DEVELOPMENT REVIEW BOARD - HYDROLOGY SECTION
 Renée Brissette, PE, Senior Engineer | 505-924-3995 rbrissette@cabq.gov

DRB Project Number: 2019-002905 Hearing Date: 01-15-2020
 Project: Lot 2-A-2-1 & 2-A-2-2, Block 2, Sunport Park Agenda Item No: 11

SUBDIVISION SKETCH PLAT OF  
**LOT 2-A-2-1 AND 2-A-2-2**  
**SUNPORT PARK**

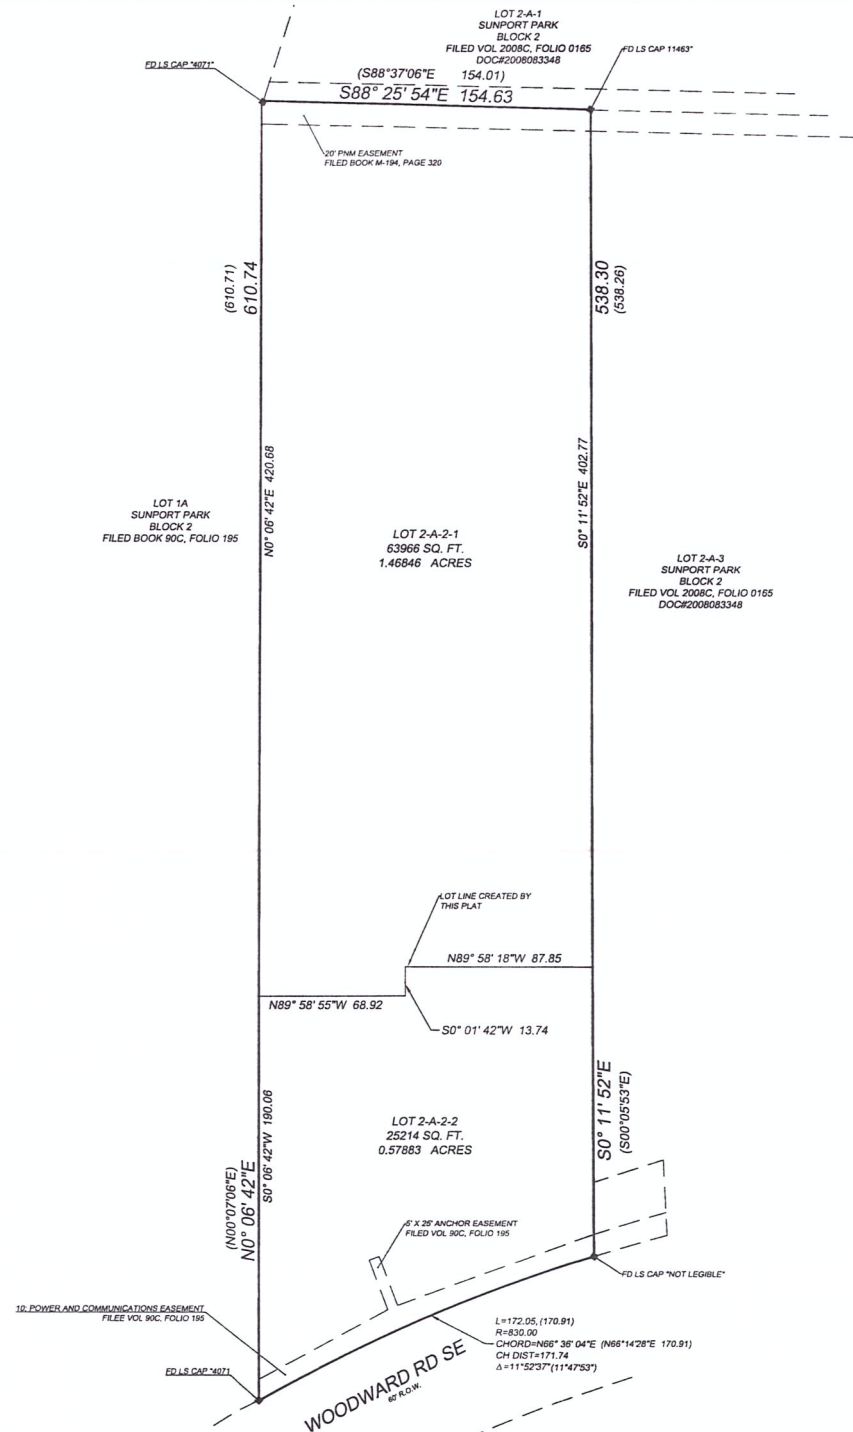
- Hydrology has no objections to the Preliminary Plat.
- Approved Grading and Drainage Plan is required prior to Building Permit if one of these conditions is met. (500 cy of grading, 1,000 sf of proposed building, or 10,000 sf of proposed paving).
- Comment – Lot 2-A-2-1 according to the Master Drainage Plan has an allowable discharge rate of 3.4 CFS/AC.
- Comment – Lot 2-A-2-2 according to the Master Drainage Plan has an allowable discharge rate of 4.0 CFS/AC.
